CITY OF ALBUQUERQUE

RE: AFD Fire Station 4
Grading and Drainage Plans
Engineer's Stamp Date: no stamp
Hydrology File: H14D120

Based upon the information provided in your submittal received 06/28/2024, the Grading & Drainage Plans **are not** approved for DFT Concept Approval. The following comments need to be addressed for approval of the above referenced project:

HYDROLOGY PLAN

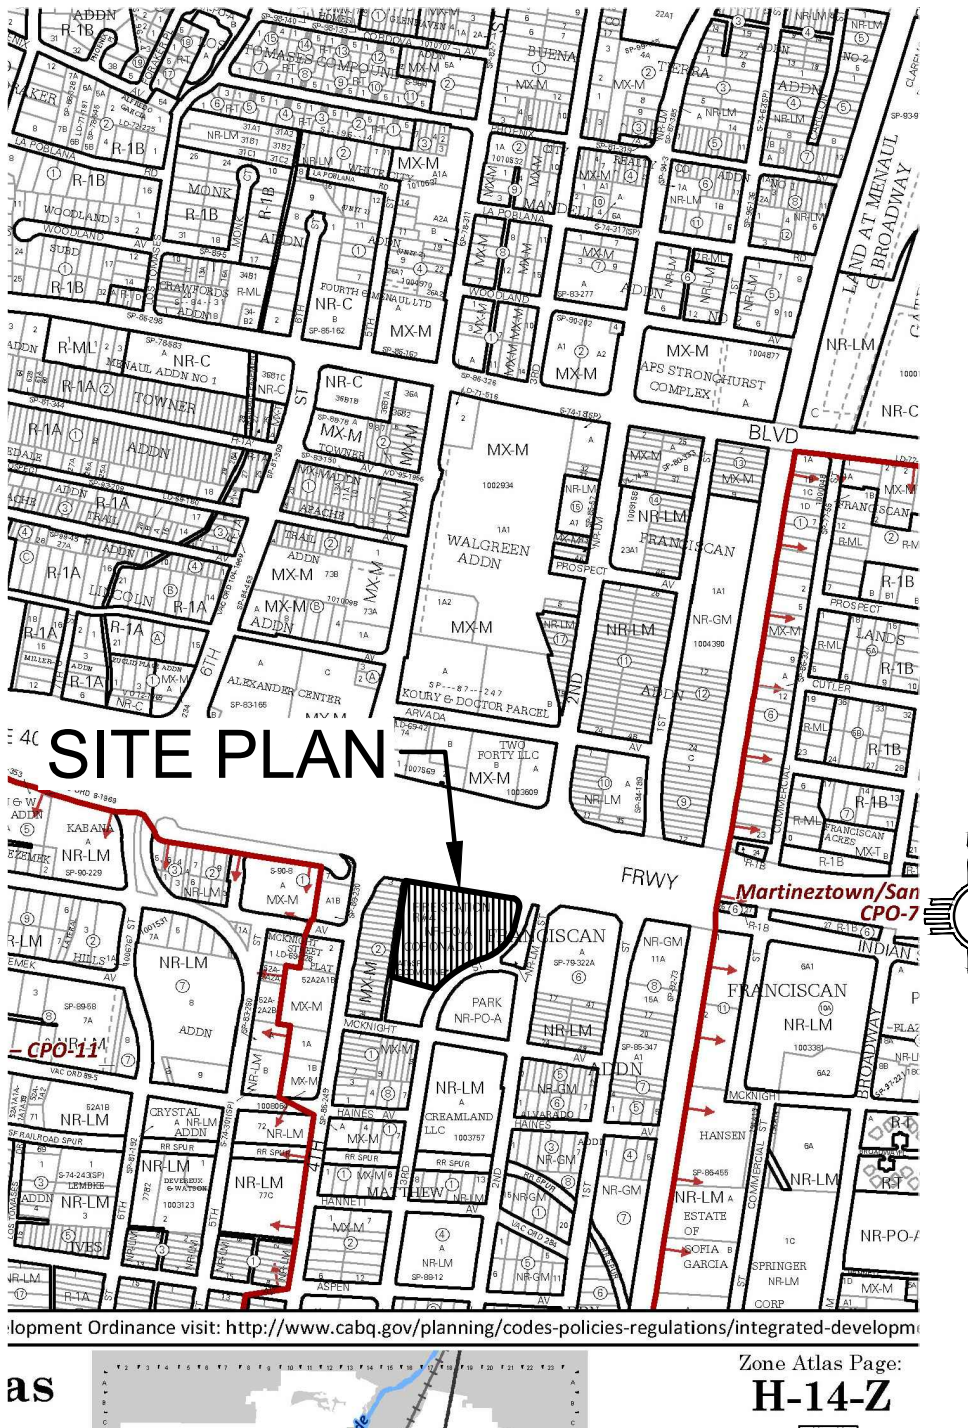
SHEET CG-101

1. Drainage Report – Existing Conditions – Add to the section that this site is within the Mid-Valley DMP and can only discharge as if it were a park.
2. Verify the calculations for Ew, V(100-6), V(100-24), and Q(100).
3. Check the Flood Zone Map referenced. The FEMA Flood Map Service Center shows: 35001C0332G – 9/26/2008.
